Application Ref:	3/2026/0354			 Ribble Valley Borough Council www.ribblevalley.gov.uk
Date Inspected:	26/06/26	Site Notice:	26/06/26	
Officer:	AR			
DELEGATED ITEM FILE REPORT:				
				APPROVAL

Development Description:	Proposed demolition of existing side extension and rear conservatory. Construction of new two-storey side extension and single-storey rear extension.
Site Address/Location:	13 Brookside Old Langho BB6 8AP

Notes
This drawing is the property of IDC Home Architecture Ltd and copyright is reserved by them. This drawing is not to be copied or disclosed by or to any unauthorised persons without the prior written consent of IDC Home Architecture Ltd.

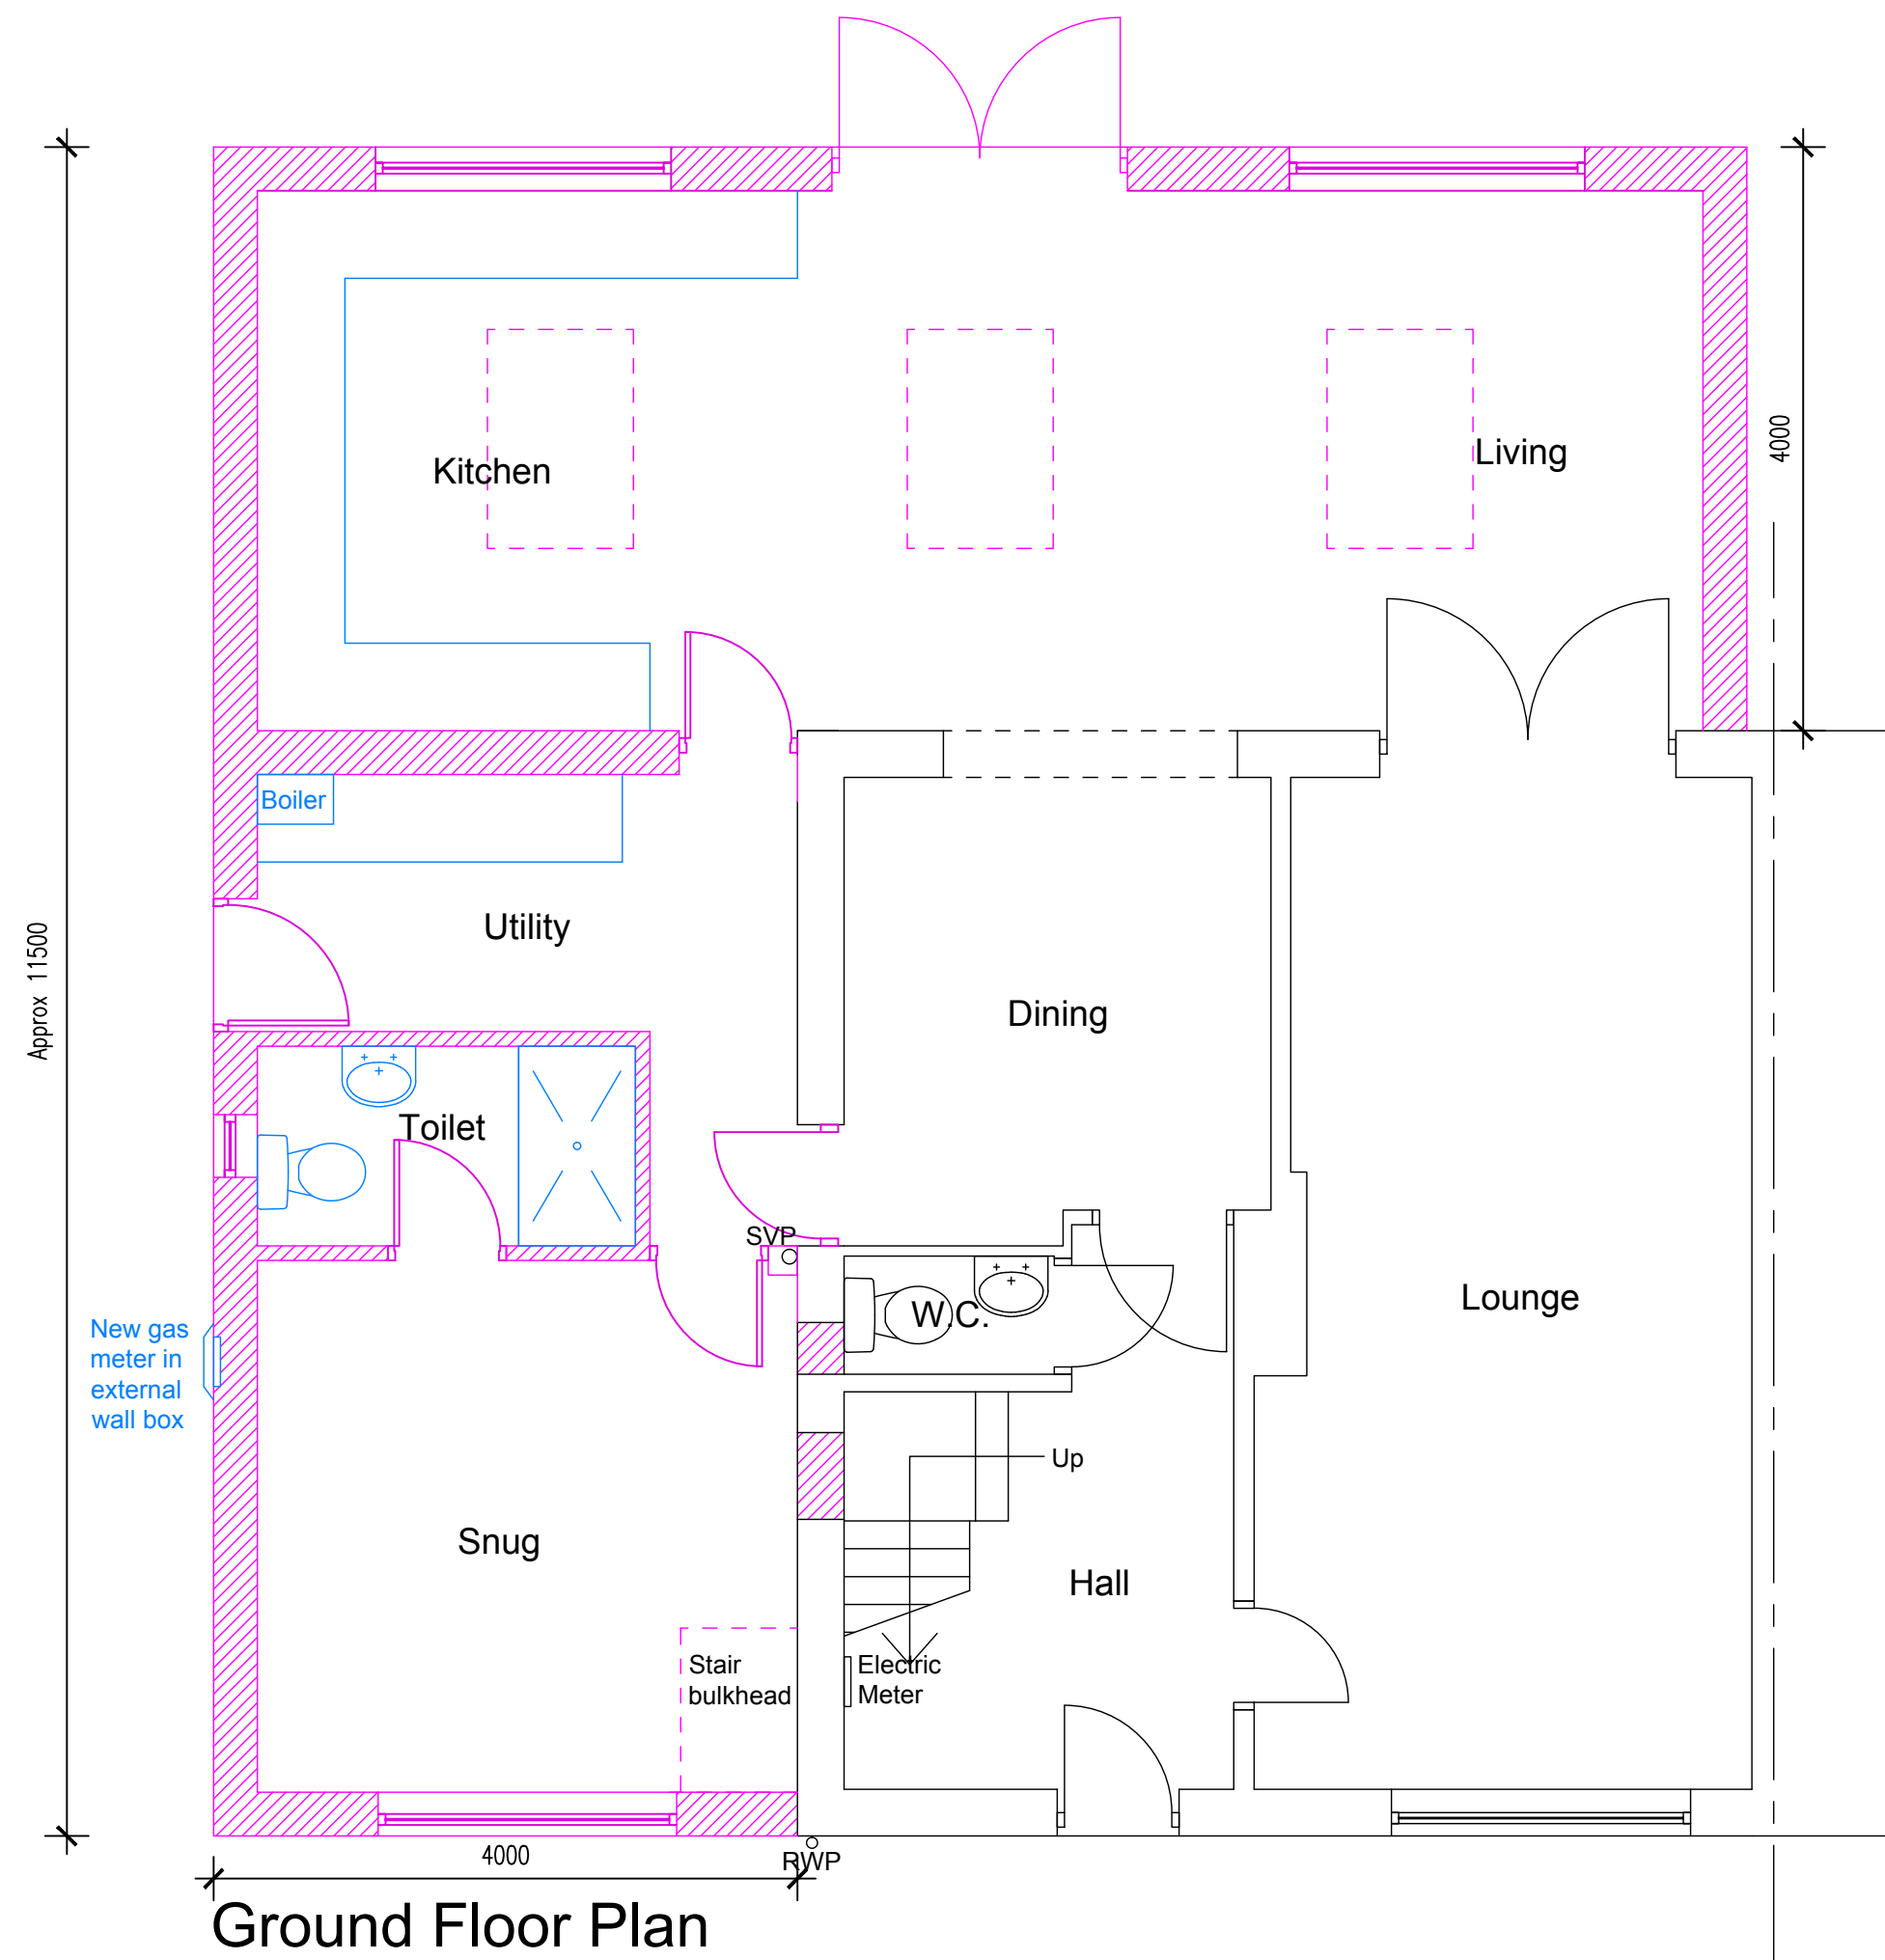
The proposed openings to the front and rear elevations of the two-storey extension would offer views comparable to those currently provided by the existing window arrangement of the main dwelling. The openings proposed to the north-western side elevation would face habitable room windows on the gable elevation of the adjacent property at No. 12 Brookside. However, these new proposed openings would be set approximately 9 metres from the first-floor windows on No. 12 Brookside’s side elevation. To mitigate any potential impacts on privacy, it is recommended that these windows be conditioned to be obscure glazed.

Ordinarily, the Local Planning Authority seeks to ensure that two-storey extensions are both set down from the main ridgeline and set back from the principal elevation. This approach is intended to ensure that extensions appear subservient to the main dwelling. In this case, such amendments were requested prior to determination; however, the applicant did not submit revised plans addressing the planning officer’s concerns regarding potential visual impact. As a result, the proposed extension would be flush with both the principal elevation and the main ridgeline of the dwelling.
